Comments needed - 169 Newbury Street

Please see my attached Survey Review of 3 18 2016.

**GRADING AND UTILITIES PLAN**

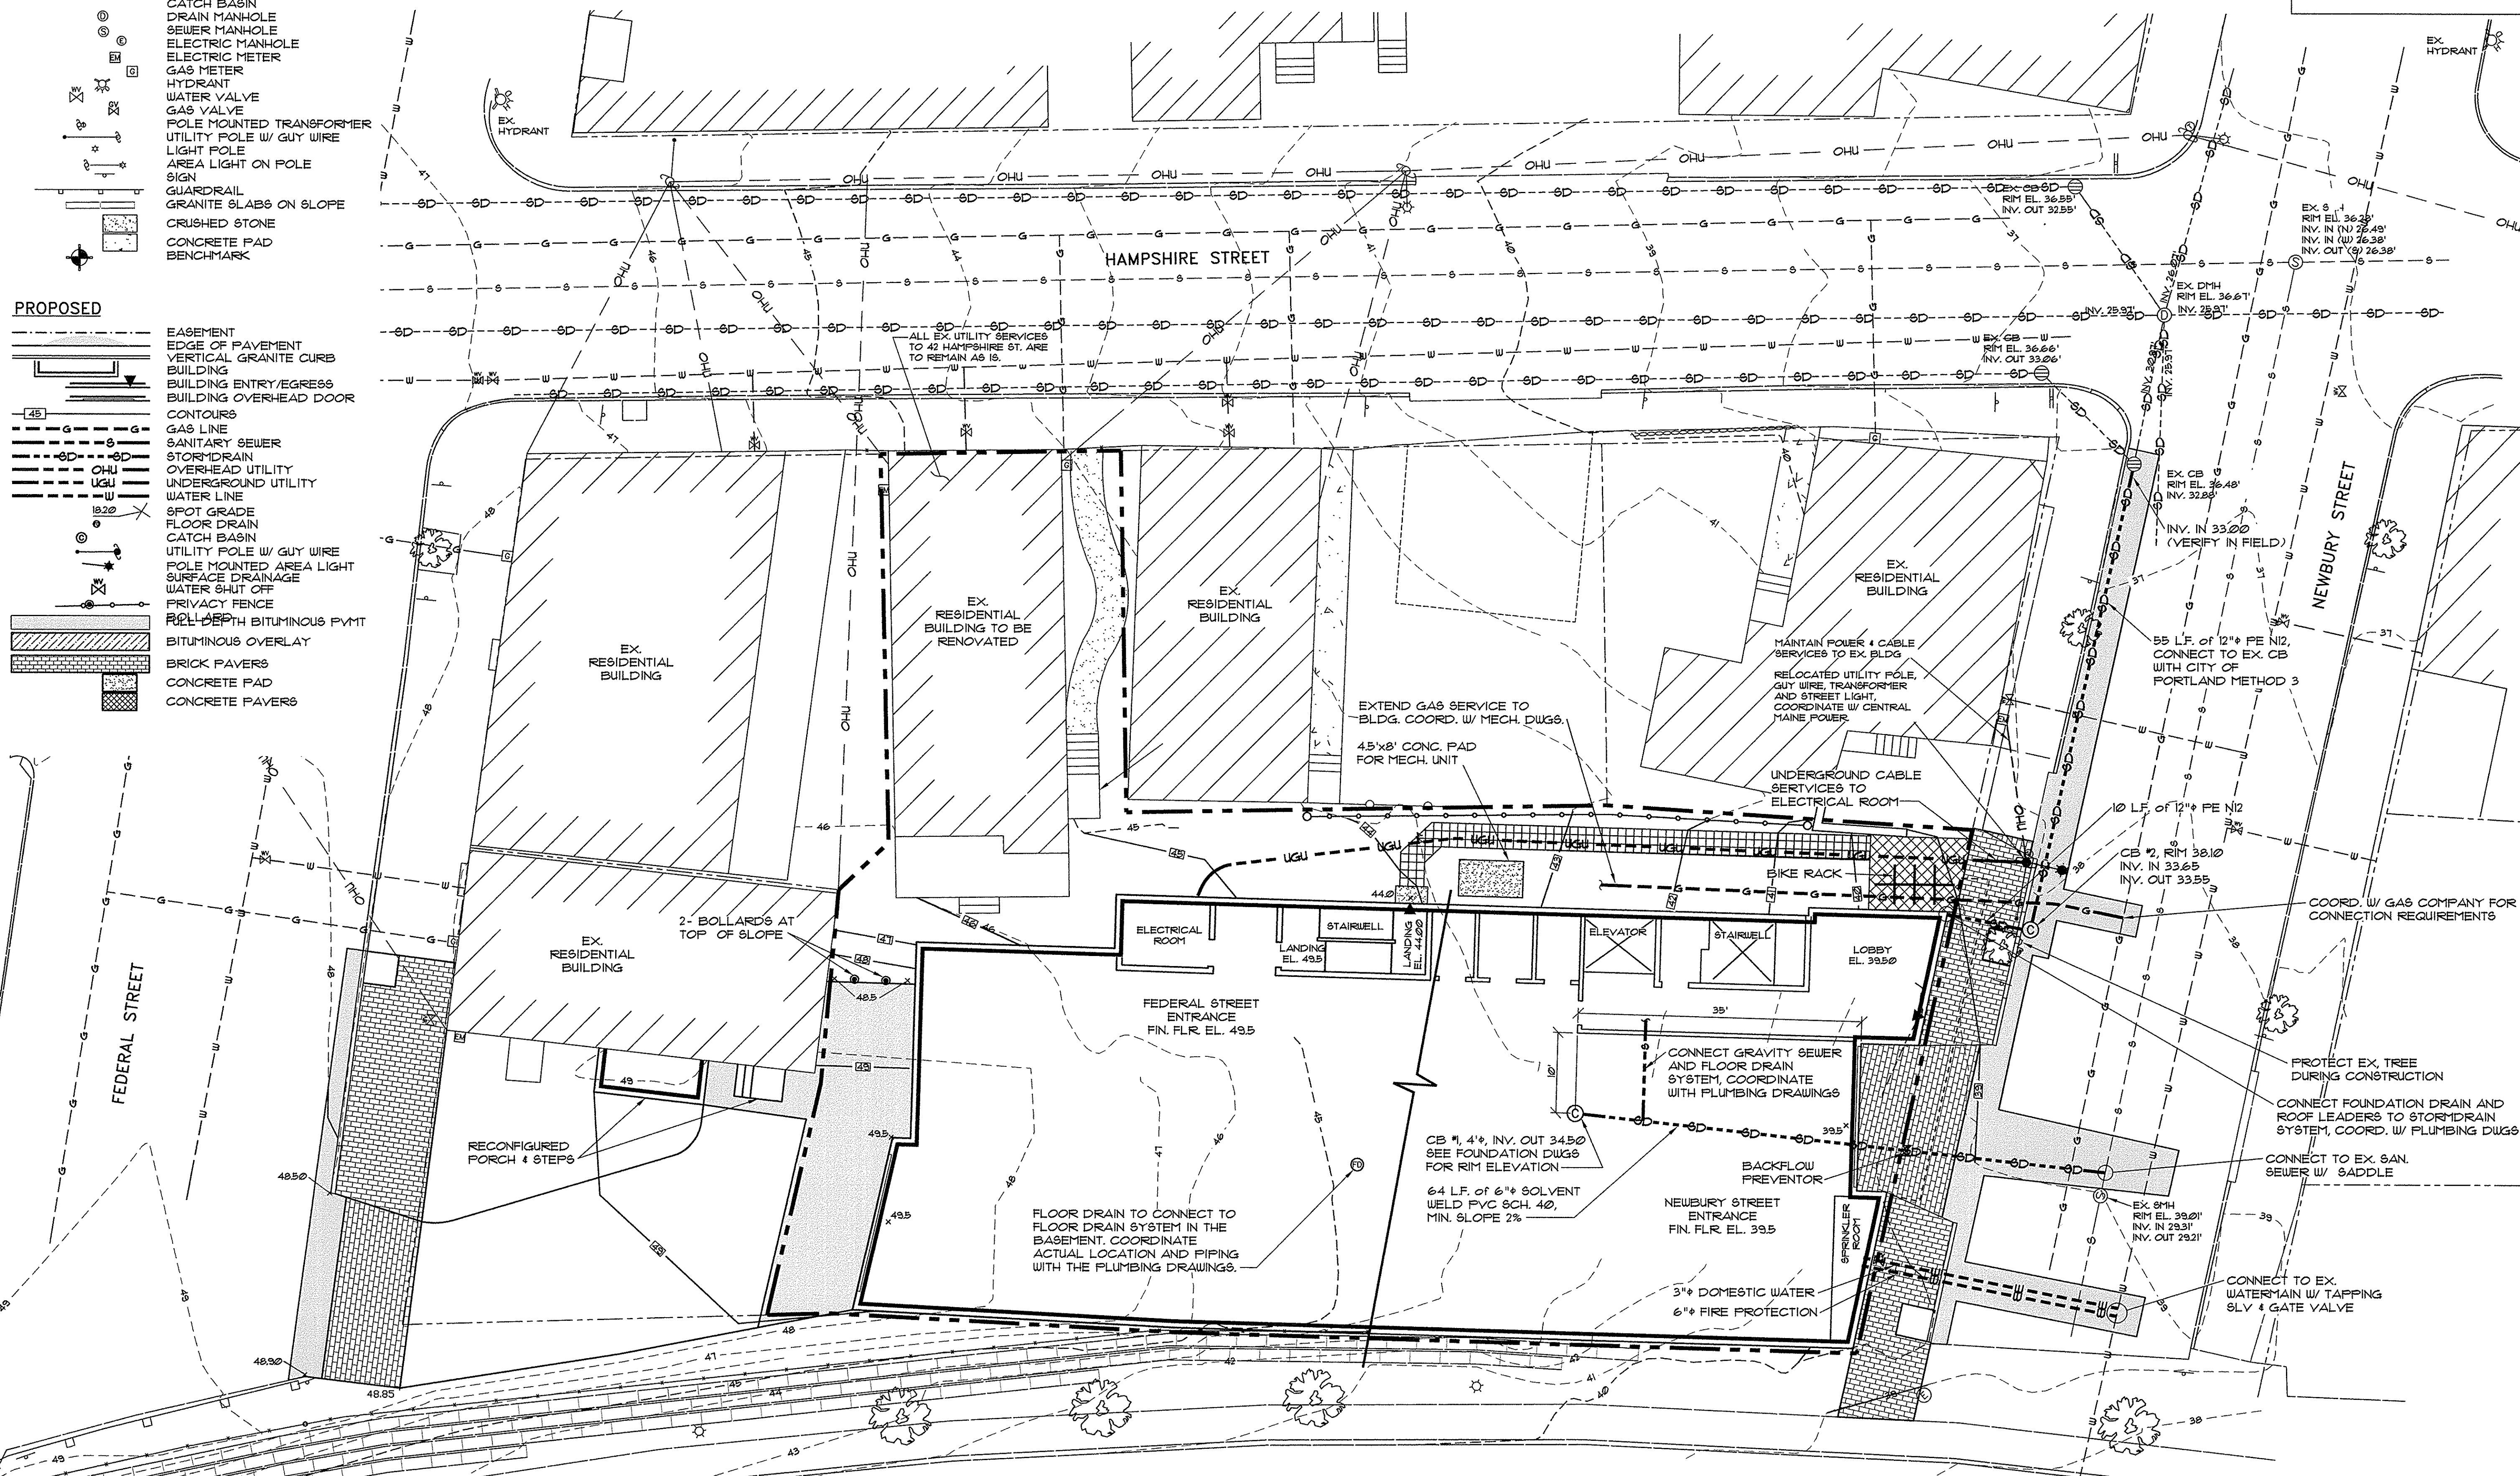
3. Footings distances into street ROWs.
4. Detail for distance from footing license line F5 to Franklin Street ROW line angle point.
5. Detail for distance from footing license line F1 to easterly property corner on Newbury Street.
